MARINE RESTORATION & CONSTRUCTION LLC

April 21, 2022

Re: SHL22-006 and SEP22-005 – Response to Notice of Incomplete Application, 9843 SE 42nd Place

We received *Notice of Incomplete Application for File Nos. SHL22-006 and SEP22-005* dated April 4, 2022. We have addressed all three comments in the section below.

PROPOSED PLAN VIEW
 SCALE: 1" = 20'

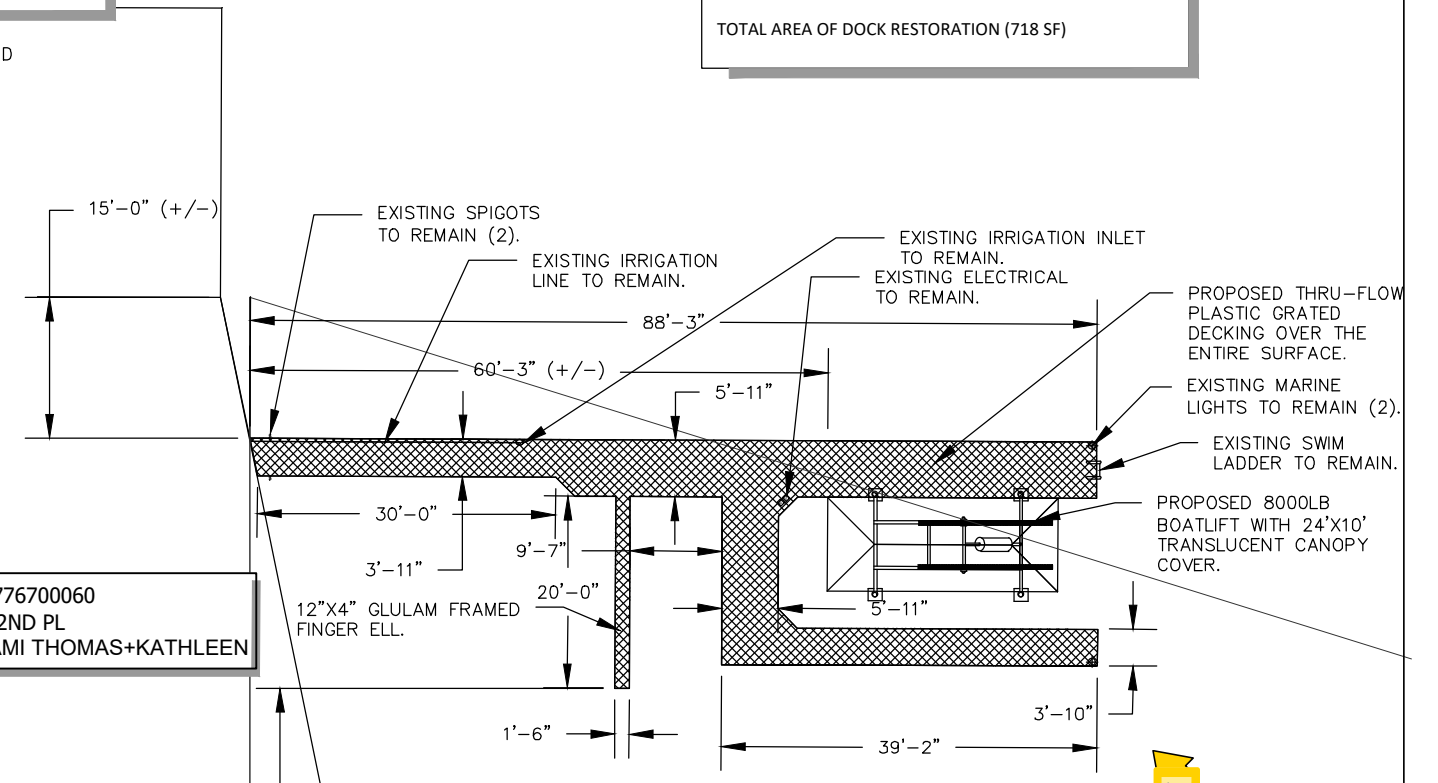
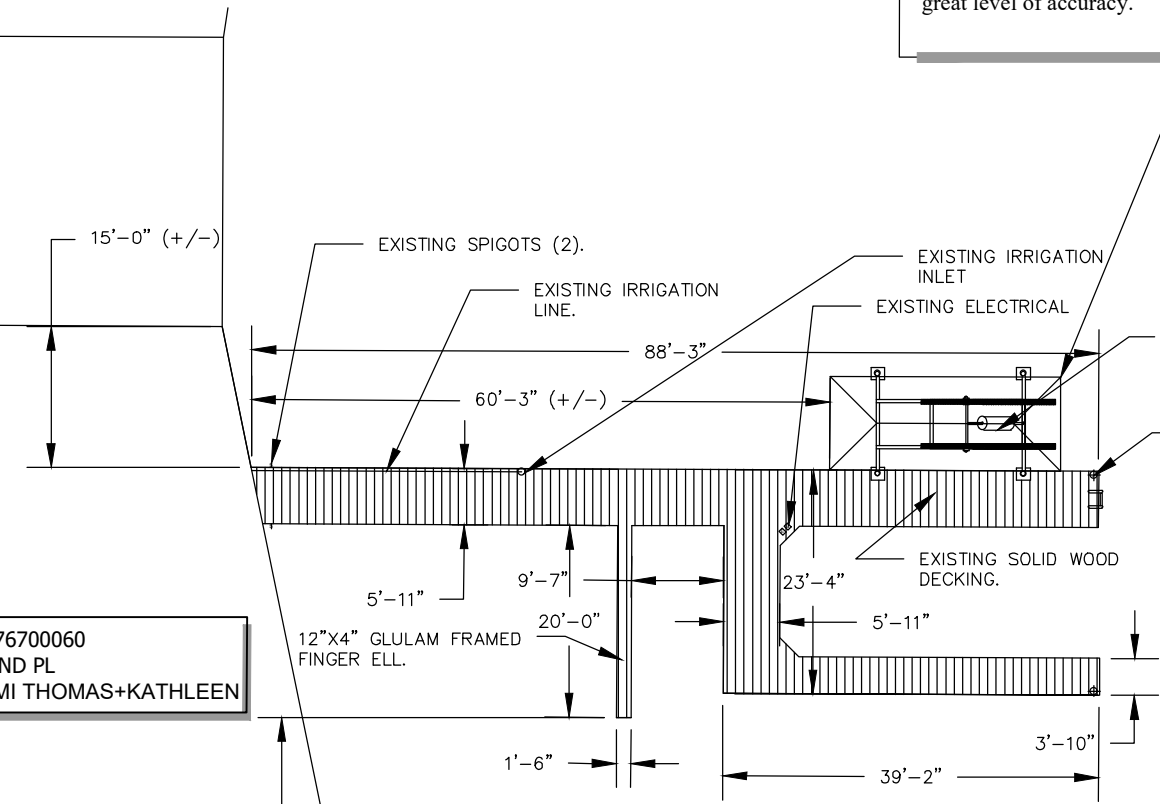
1. Because the existing boatlift is not permitted in its current location, we cannot consider the relocation as replacement, repair, and maintenance, therefore, it is considered a new moorage facility. Please provide a narrative demonstrating the boatlift's compliance with all the standards in MICC 19.13.050.F(1) *Development standards for new and expanded moorage facilities.*

Any possible net loss of ecological functions has been addressed by maintaining vegetation in the existing mitigation plan. The attached, proposed mitigation plan meets the standards outlined in MICC 19.13.050.F(1)(iii) and Figure C. The proposed boatlift location will be 60' 3" from the OHWM All work windows established by the U.S. Army Corps of Engineers and the Washington Fish and Wildlife will be followed.

PROPOSED FRAMING PLAN

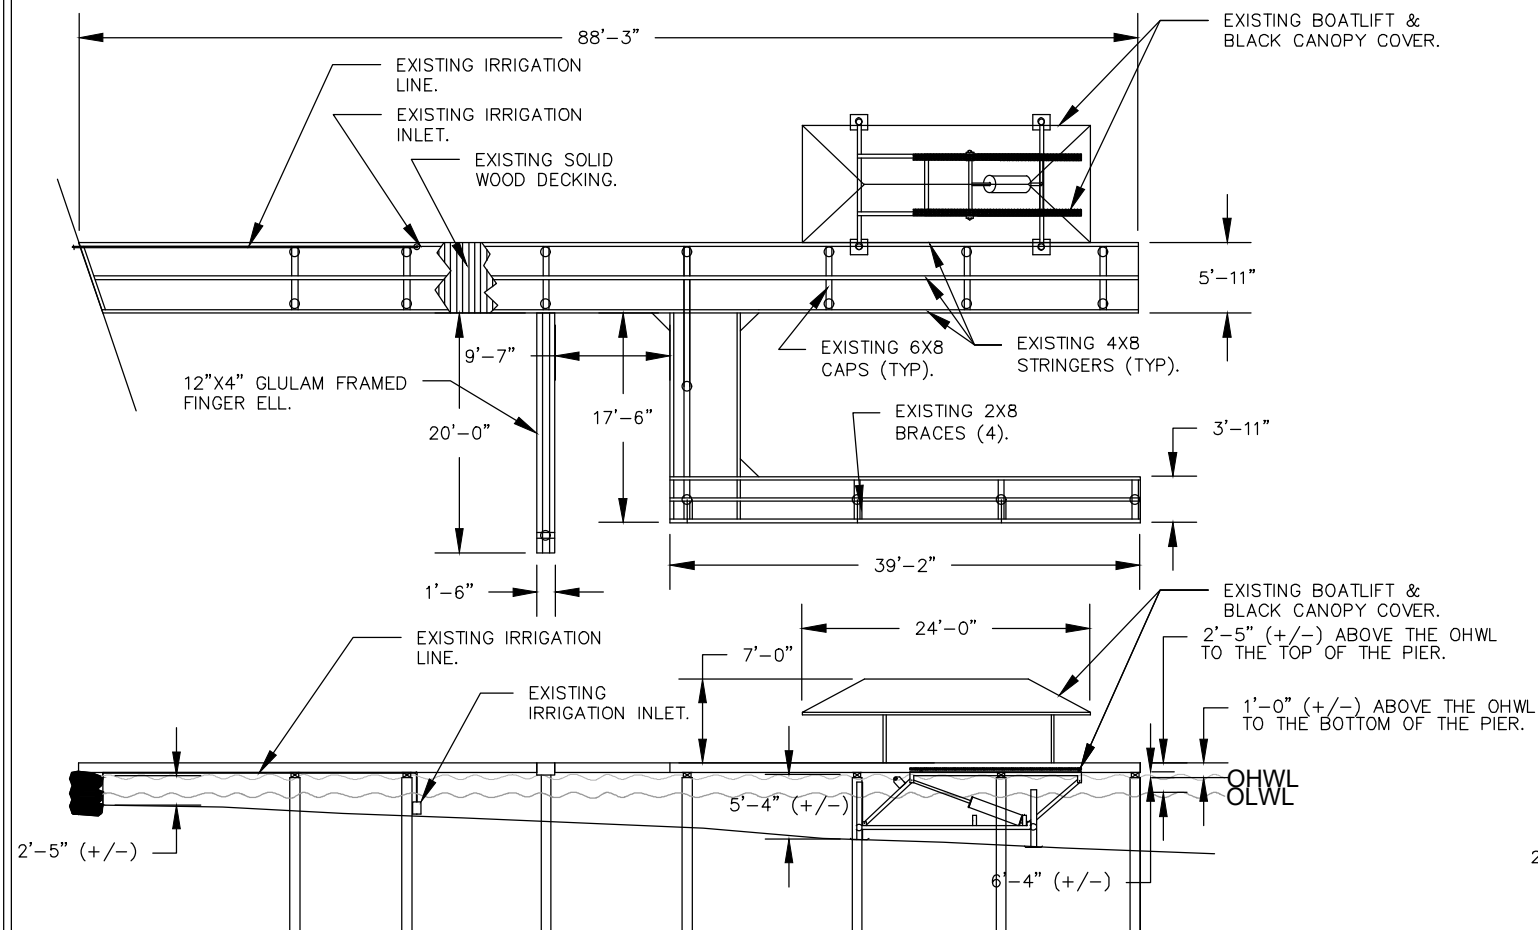
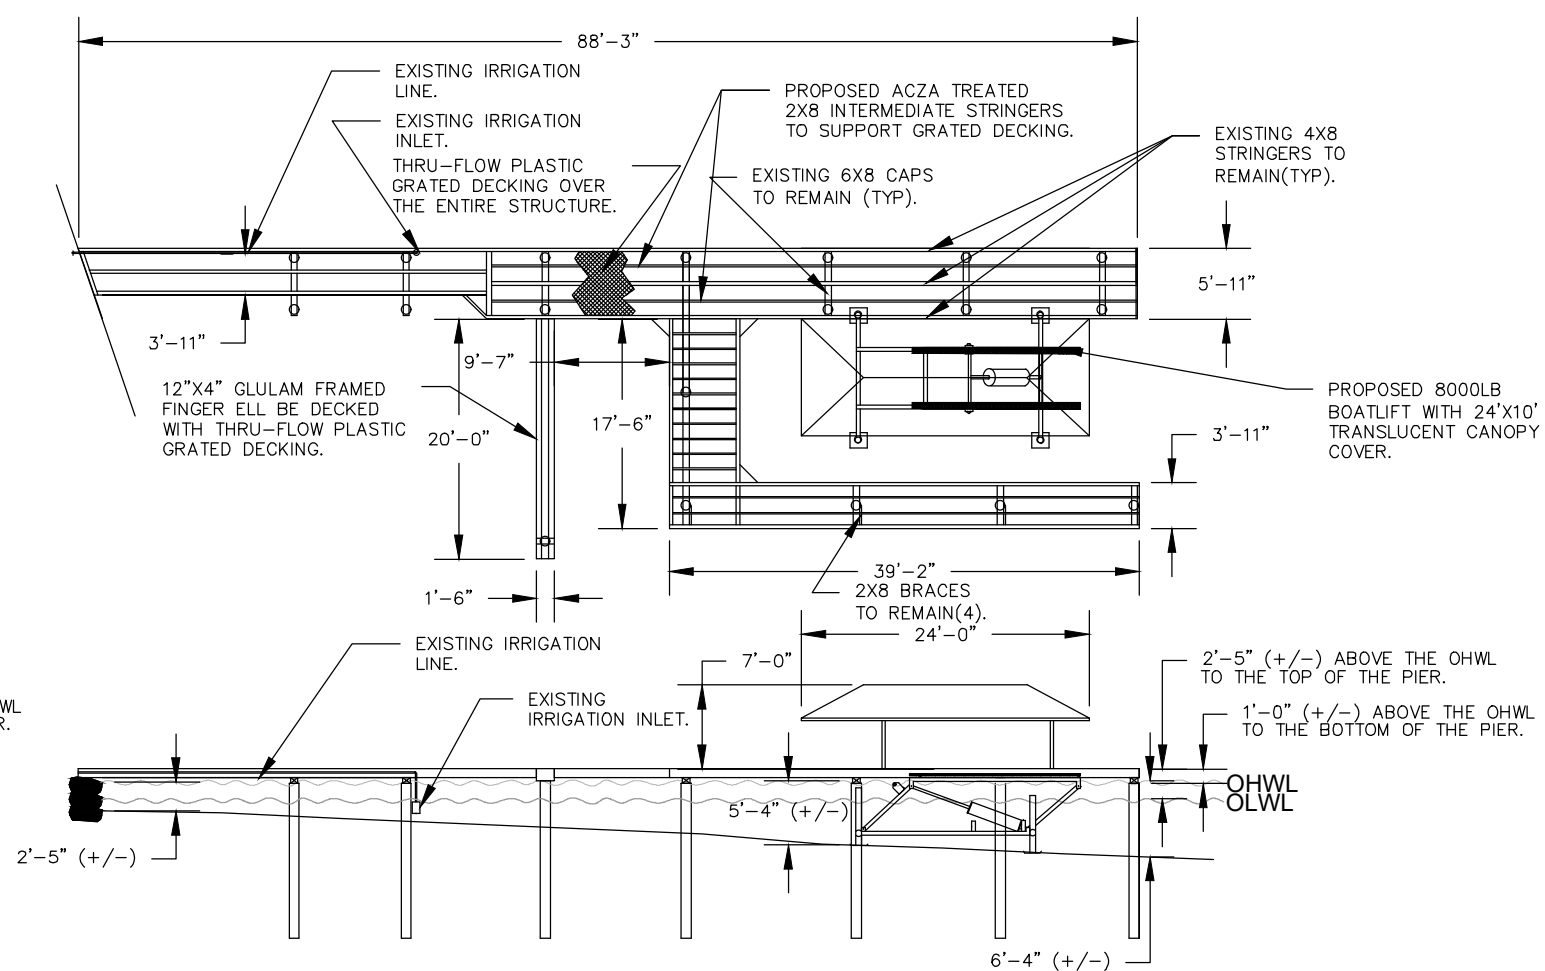
3. Provide a breakdown of the dock framing elements (total existing, and elements that will be replaced) to demonstrate compliance with MICC 19.13.050.F(2) *Structural repair.*

Please see attached, revised plan set dated April 13, 2022. The revised plan set includes a planting legend on page 8 which documents that the established native vegetation on site conforms to MICC 19.13.050.F(1)(iii) and Figure C. We have also attached Planting Area Document 2022-04-12_Hatsukami-Site.PDF which further documents the planting area and photos of the established vegetation on site.

TOTAL PLANTING AREA REQUIRED CALCULATIONS:

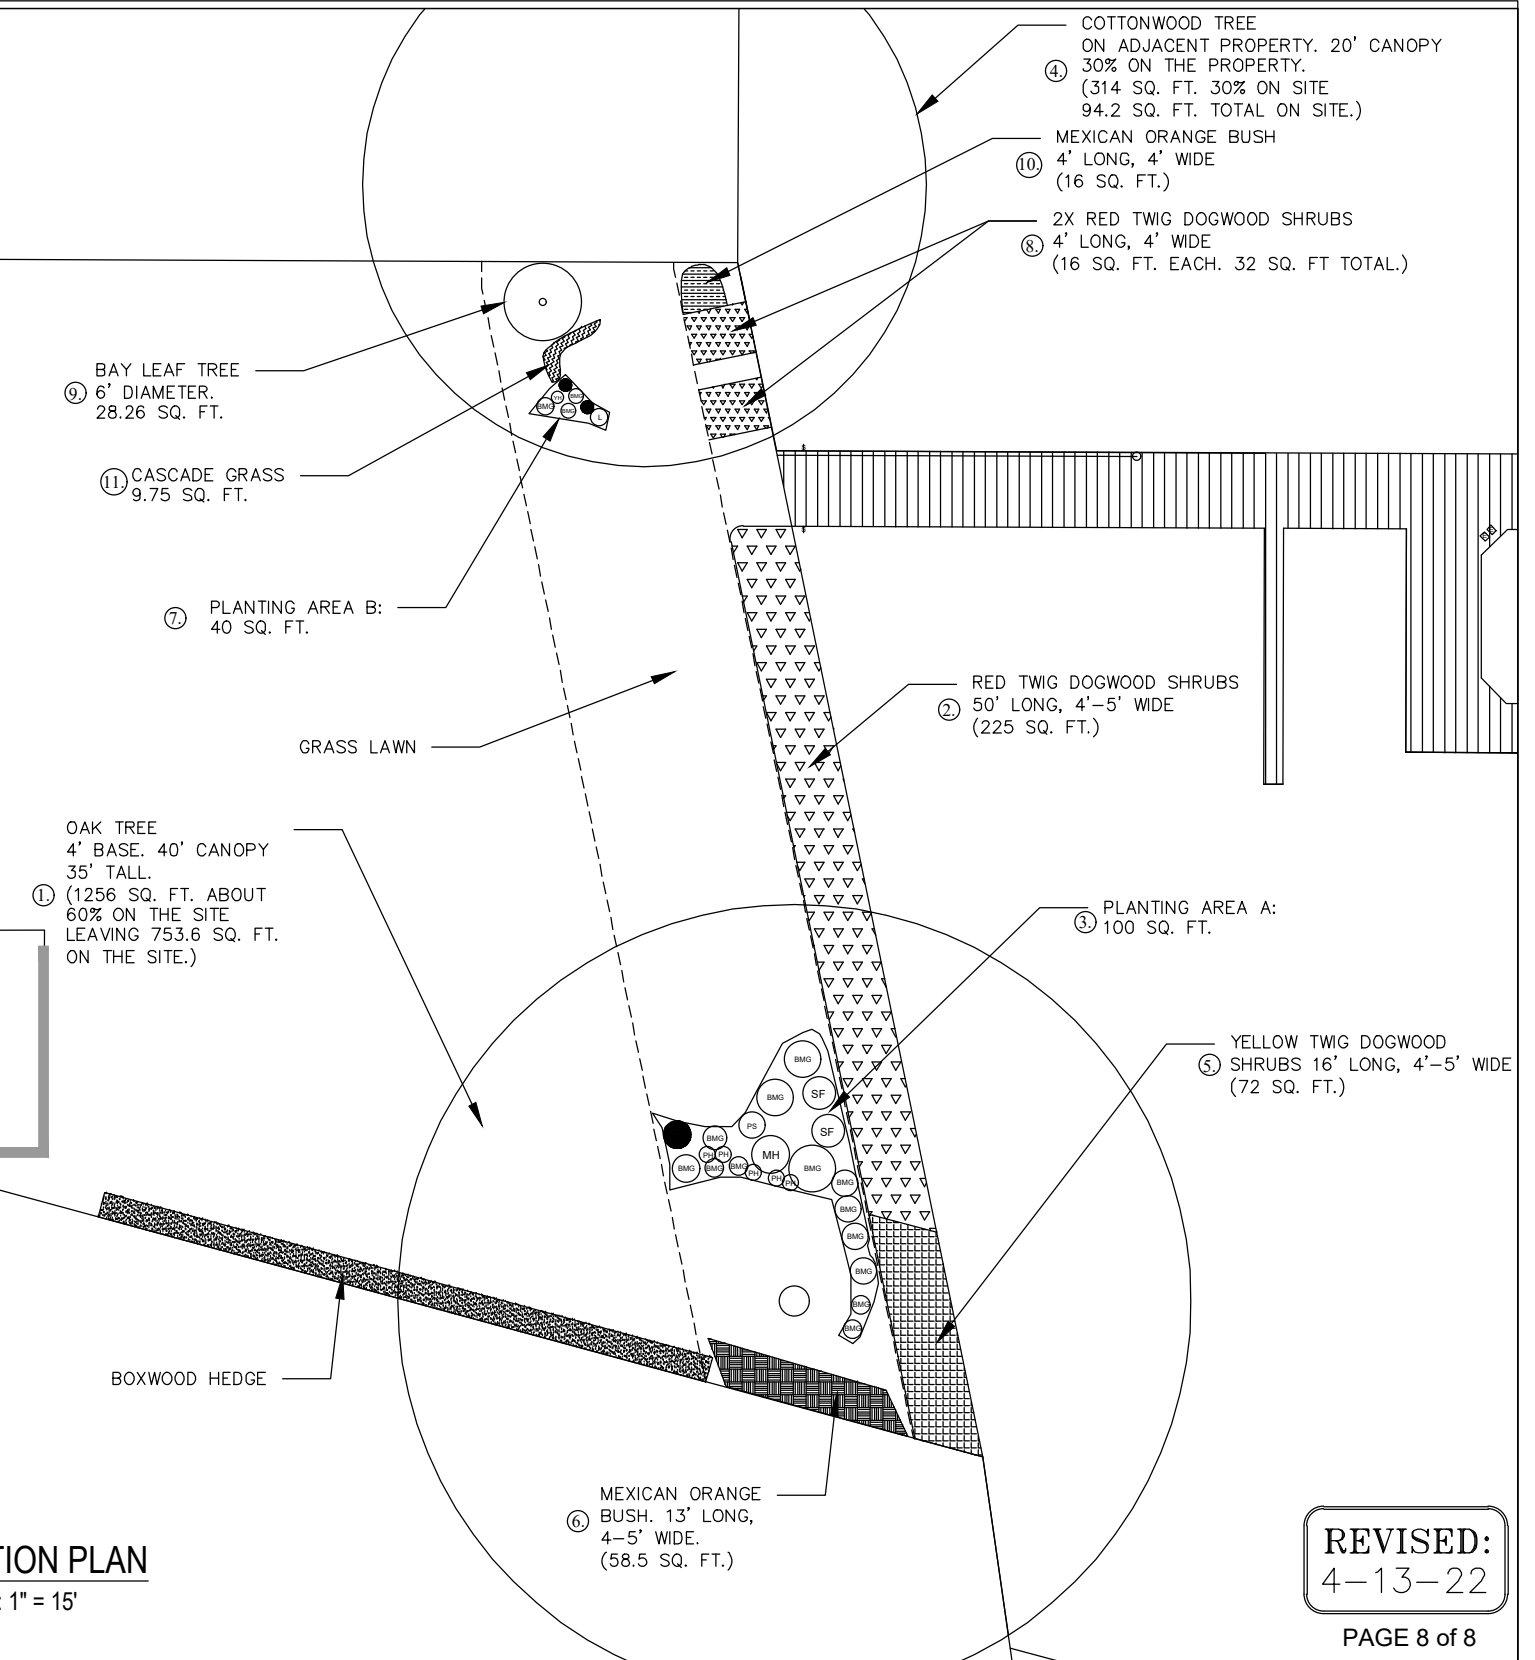
2. Provide a vegetation plan that conforms to MICC 19.13.050.F(1)(iii) and Figure C.

Please see attached, revised plan set dated April 13, 2022. The revised plan set includes a planting legend on page 8 which documents that the established native vegetation on site conforms to MICC 19.13.050.F(1)(iii) and Figure C. We have also attached Planting Area Document 2022-04-12_Hatsukami-Site.PDF which further documents the planting area and photos of the established vegetation on site.
